Ref: 20018862

Cleve Hill Solar Park – Response to CHSP comments REP2-060 / REP3-058

I have now had the opportunity to review comments provided by CHSP (REP2-060/REP3-058) to my ALC report submitted 11th June 2019 and presented in the open floor hearing, dated 16th July 2019.

Date: 22/03/2017

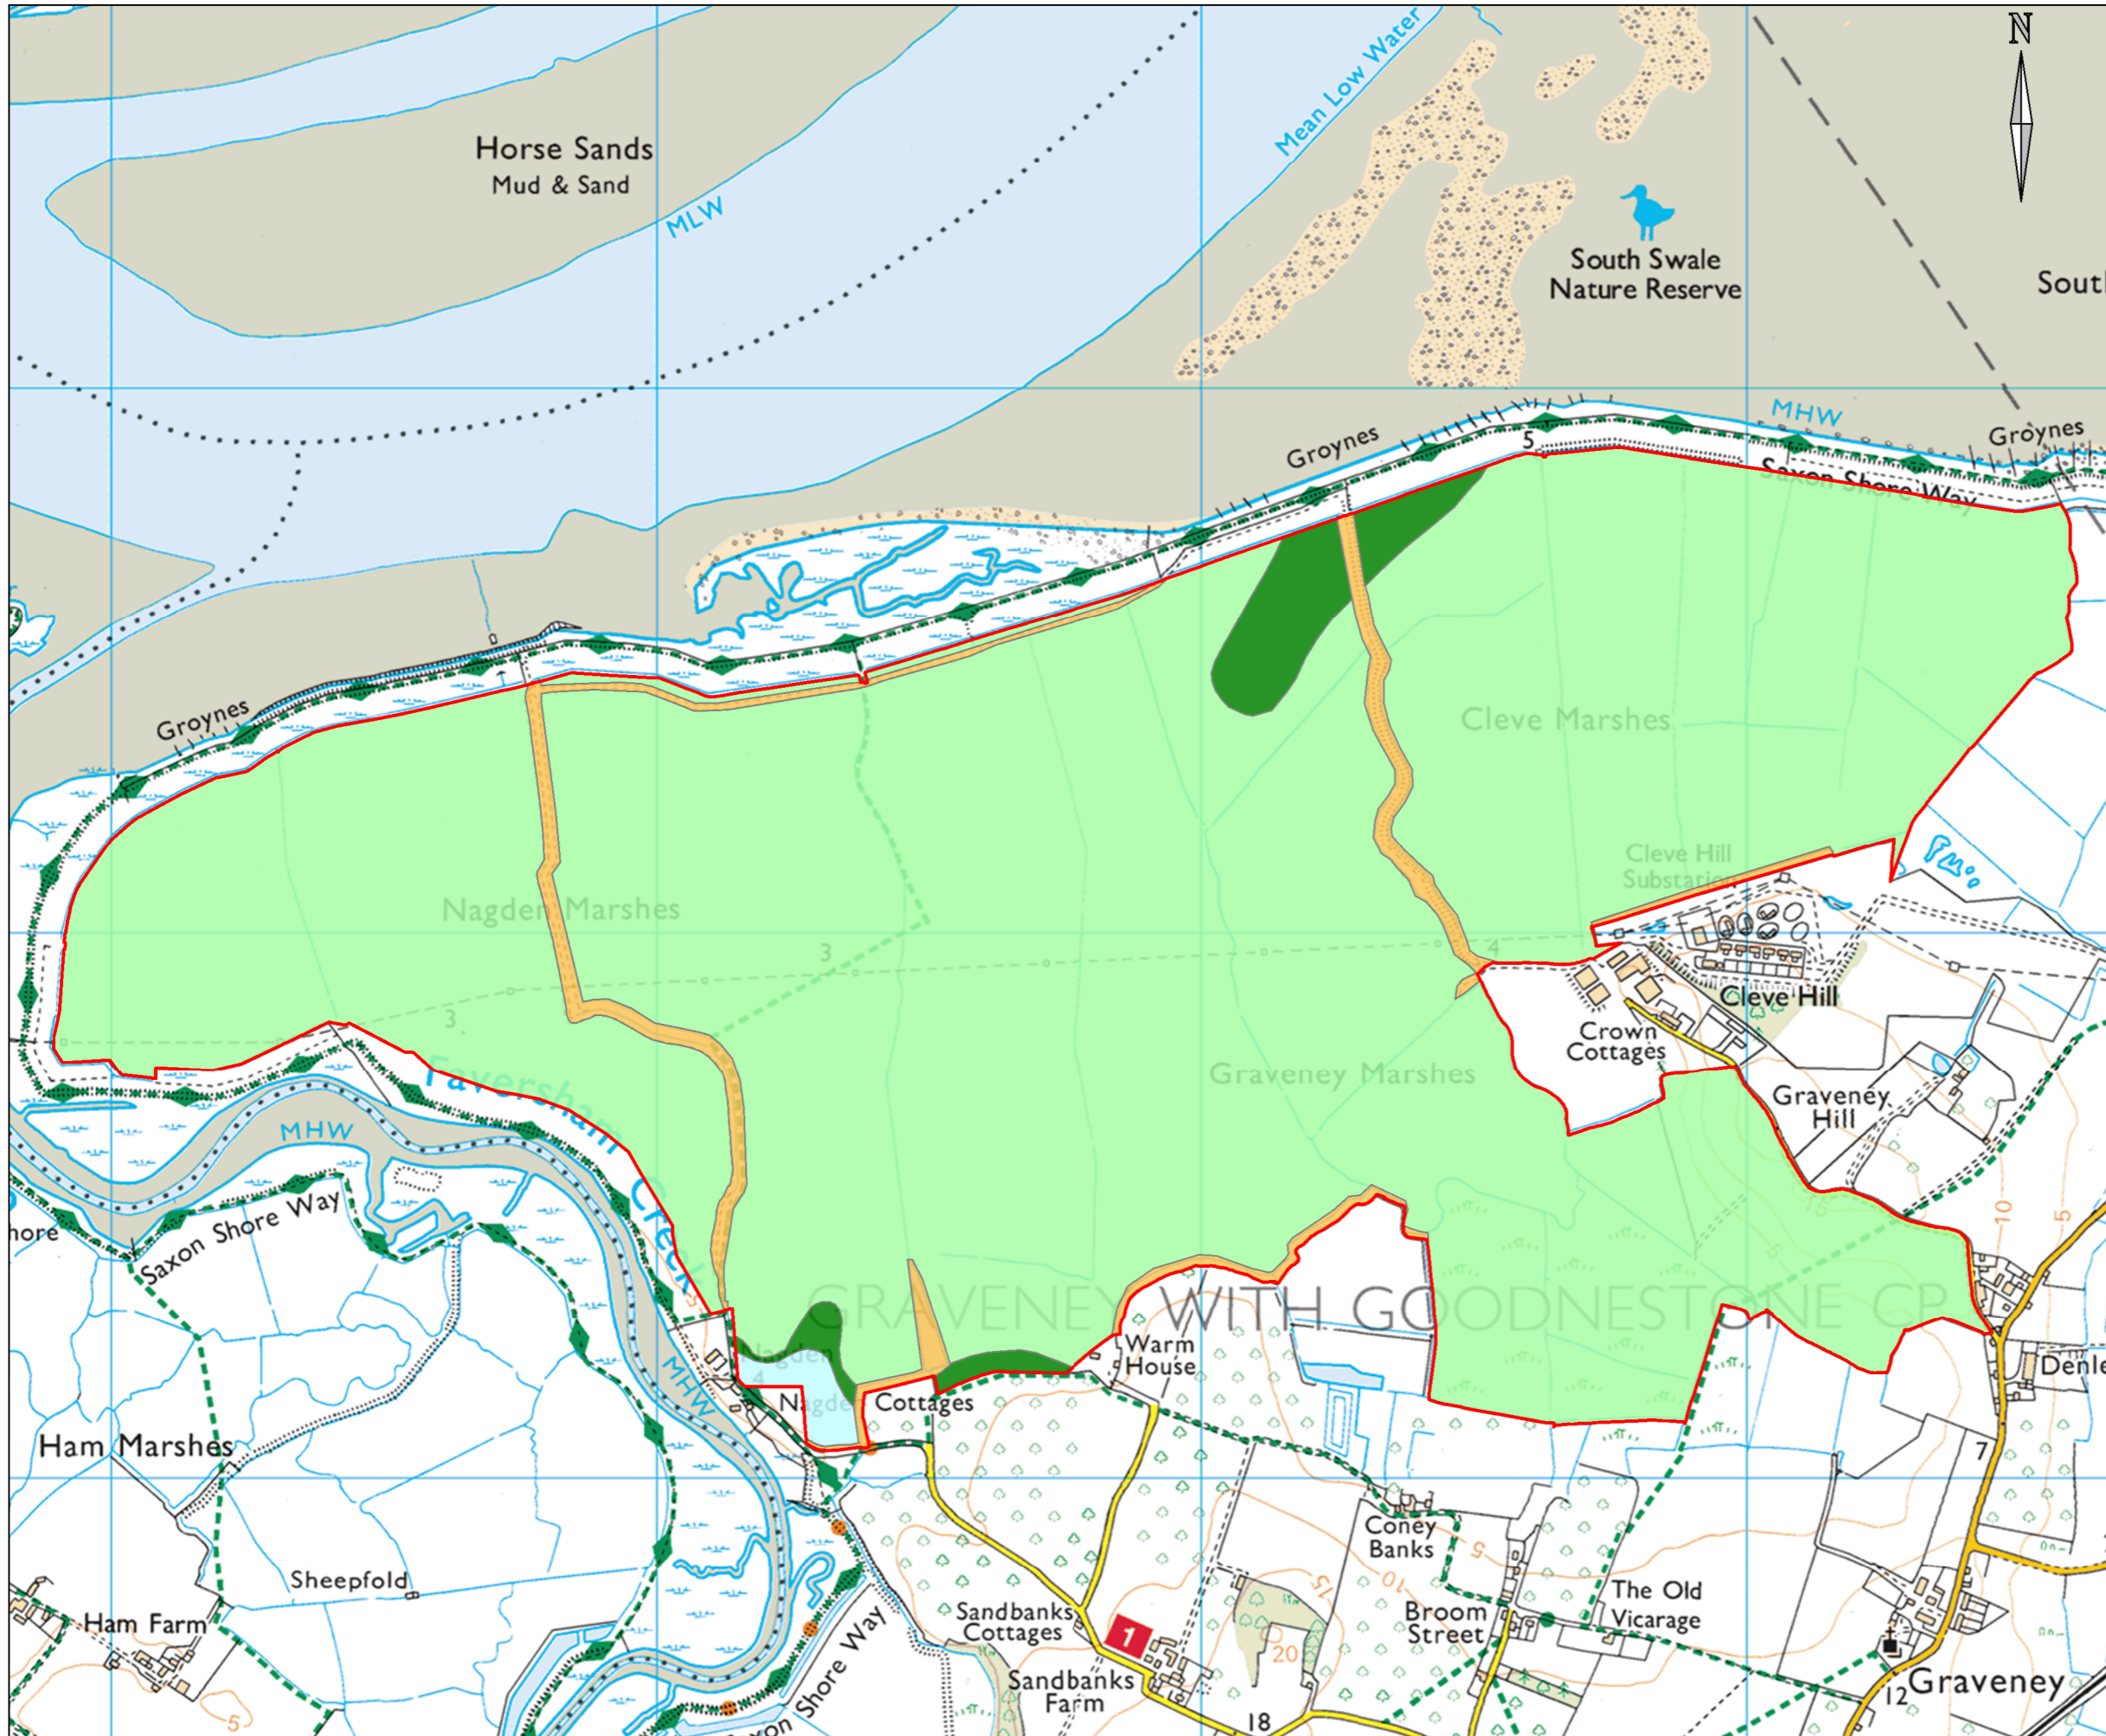
As pointed out in my previous report, three field observations namely 35, 37 and 54, should have been referred to Figure 8 (instead of Figure 7), in accordance MAFF 1988 guideline 'estimation of wetness class from depth to slowly permeable layer and duration of field capacity for soils with gleying present within 70 cm depth but not within 40 cm and a slowly permeable layer starting within 80 cm depth' end of quote. Thus based on the field capacity, these three field observations should have been clearly interpreted as Wetness Class II.

Thus, for the correct interpretation of the MAFF 1988 guideline, the field observation presented in the CHSP ALC report Appendix table named ‘Land at Cleve Hill Farm: ALC and soil resources survey – details of observation at each sampling point’, namely 1, 5, 6, 7, 8, 8a, 9, 11, 13, 15, 16, 18, 21, 23, 24a, 26, 29, 32, 33, 34, 35, 36, 37, 38, 39, 41, 48, 49, 50, 51, 52, 53, 54, 55, 56, 64, 65, 66, 68, 70, 71, 80, 81, 82, 83, 84, 85, 86, 87, 95, 96, 97, 98, 99, 100, 101, 102, 104, 115, 117, 122 and 160, should have been interpreted to be subgrade 3a, due to the presence of CaCO₃.

I have now reviewed these additional observation points and identified 10 locations, which have calcareous top soils, including 124, 127, 134, 135, 138, 139, 144, 147, 149, 152 and 155.

Having now obtained the missing field observation data from CSHP, it is apparent that only one single field observation details a gradient of 9 (observation 143). This single gradient exceedance is only equivalent to about 0.5% of the total land assessed. Thus about 99.5% of the entire land has no gradient limitation and is in fact very flat and hopefully this was noted by the Planning Inspectorate during public viewing of the area. No actual field observation data are presented within the CSHP ALC report detailing gradients of 7 and 11 degrees.

- Therefore, the statement presented in the CSHP ALC report, paragraph 3.9, page 6, quote 'gradient is therefore an equally limiting factor on this land' is inaccurate, as 99.5% of the entire survey area or equivalent to 372 ha is entirely flat.
